Consultation Response from KC, Trees
2024/91451 88, Shirley Road, Gomersal, Cleckheaton, BD19 4ND
Erection of detached dwelling with associated external alterations and erection of front dormers including roof alterations to form first floor accommodation, installation of solar panels and external alterations to 88 Shirley Road
Date Responded: 17/07/2024 Responding Officer: Jack Dunn Responding Ref: 55/91

| Title: - Tree Information Plan | |

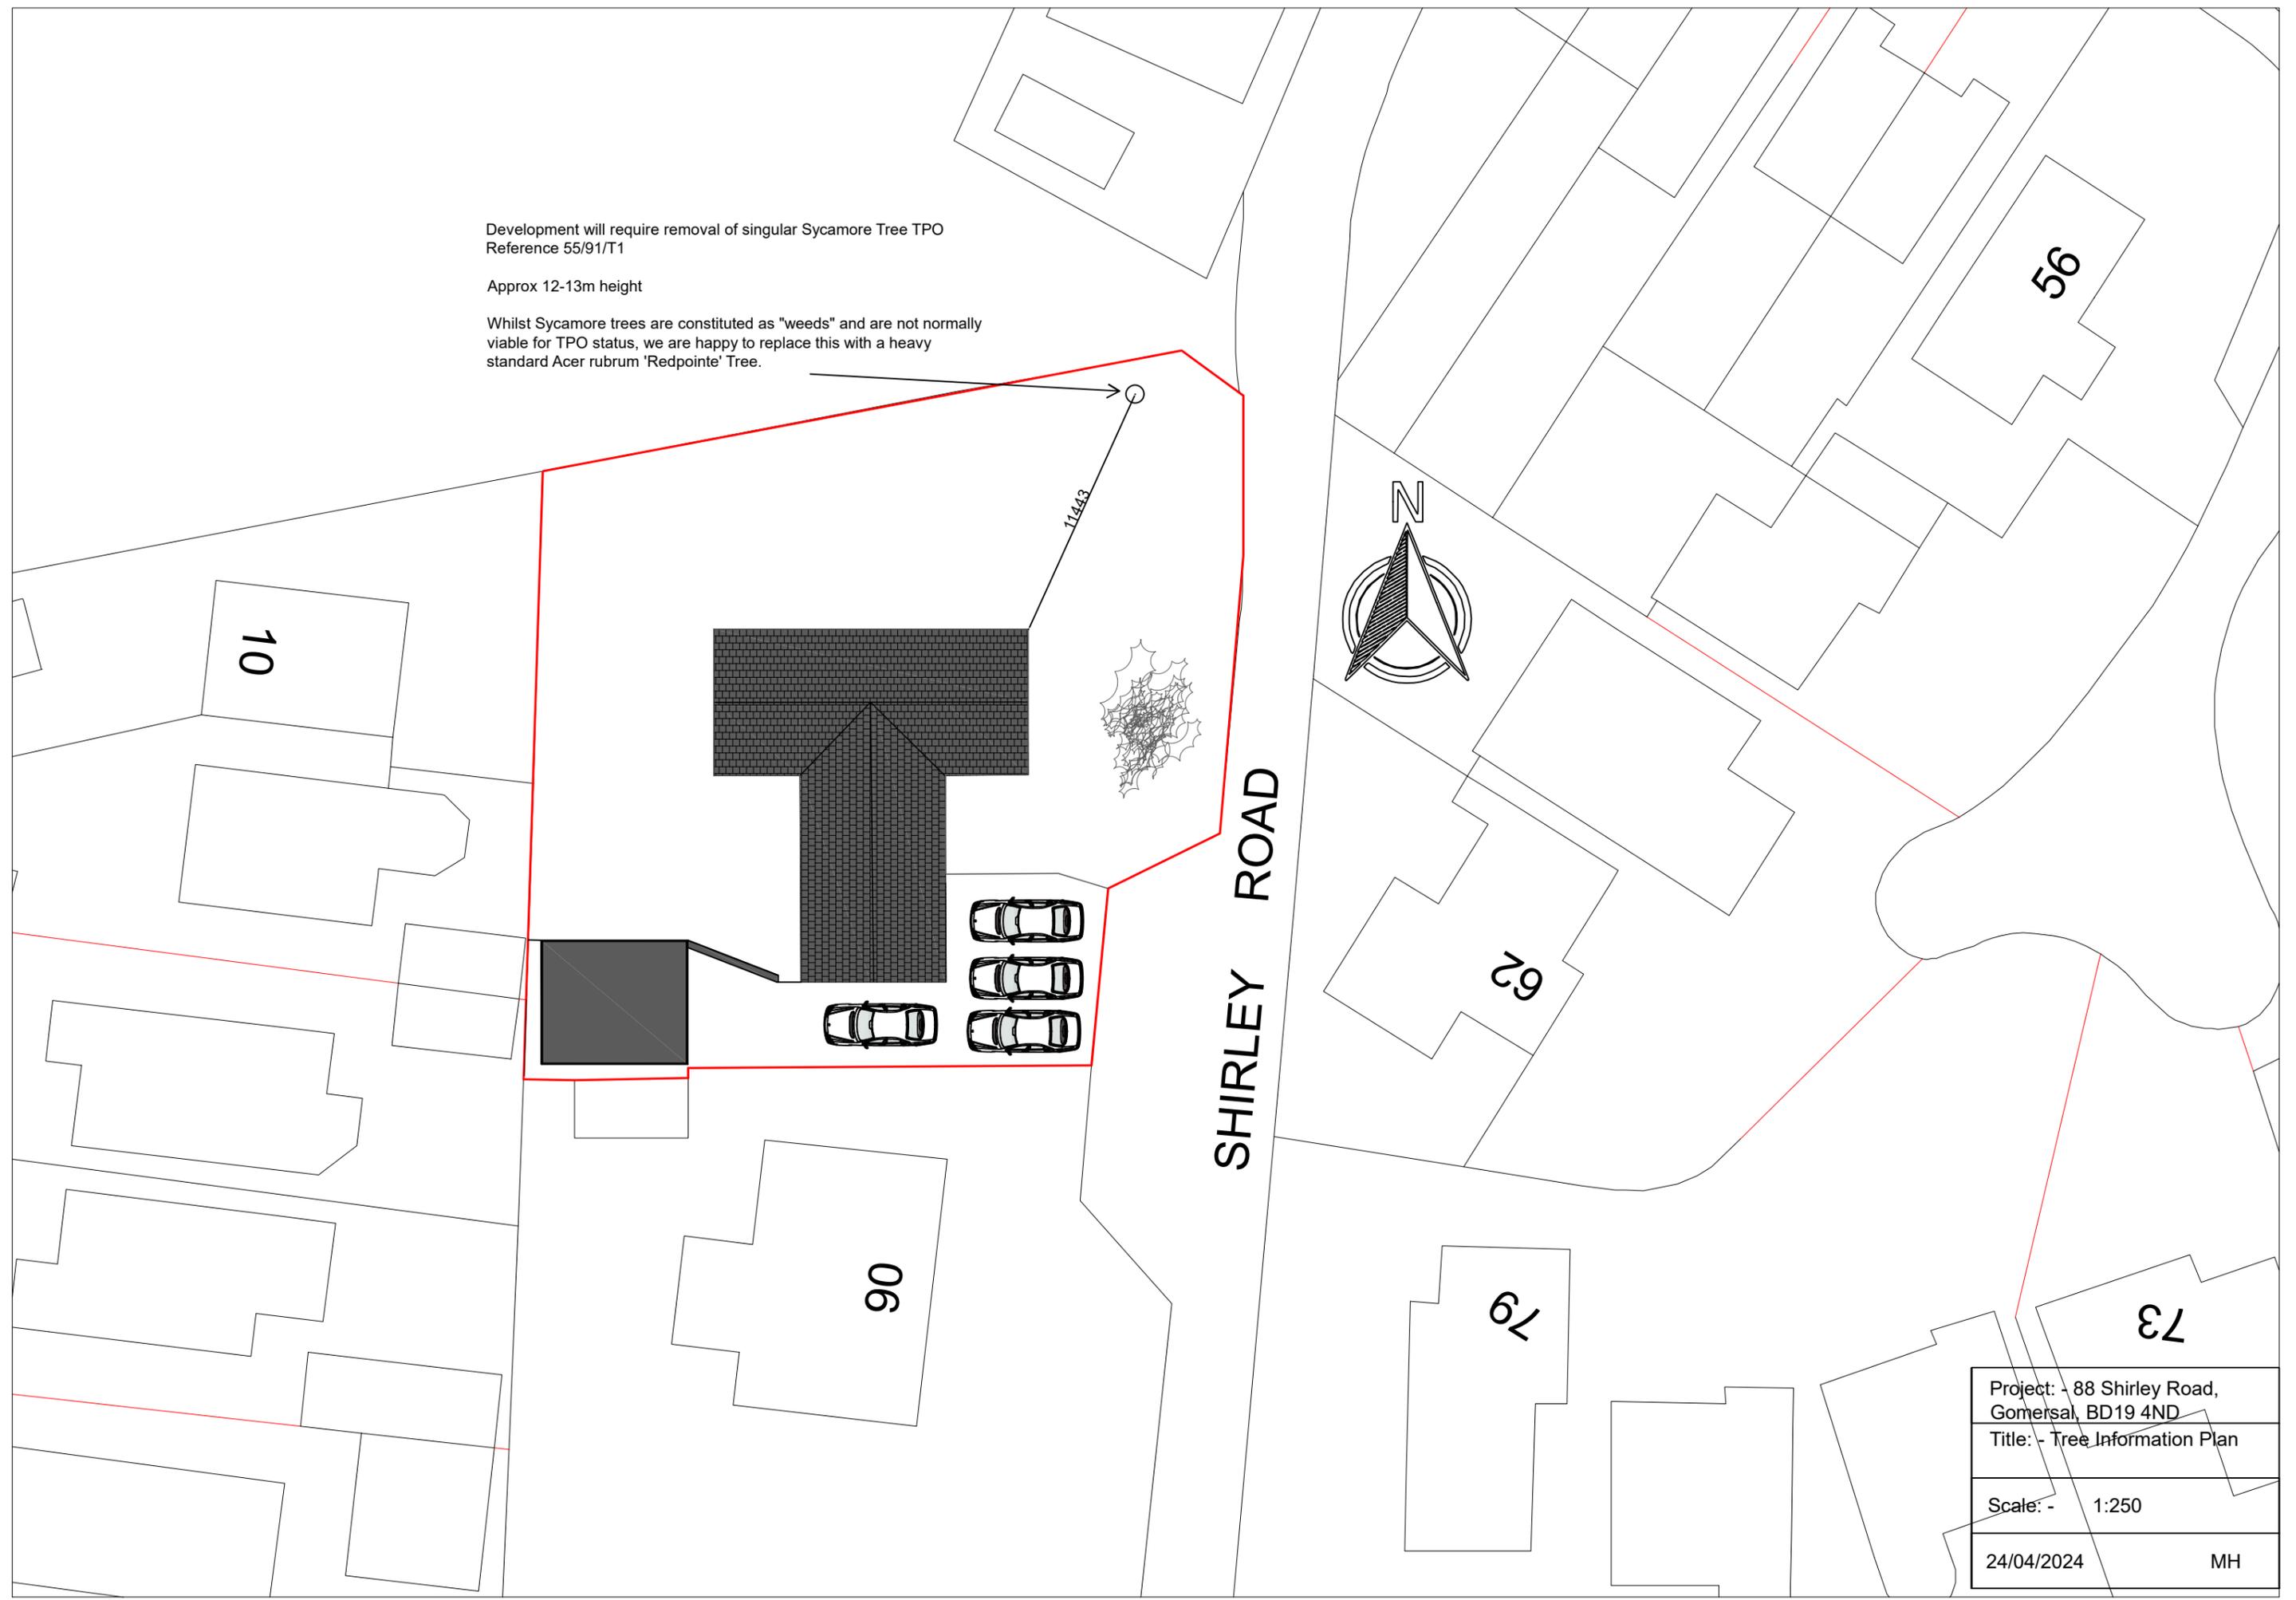
No new information or revised plans have been submitted and therefore Kirklees trees takes the same stance as previously stated. The proposals would require the removal of a protected tree and the proposed re-planting is not sufficient to mitigate the loss of a mature tree.

There is an objection as the proposals are in direct conflict with adopted Kirklees local plan policy 33 and 24 (i). It
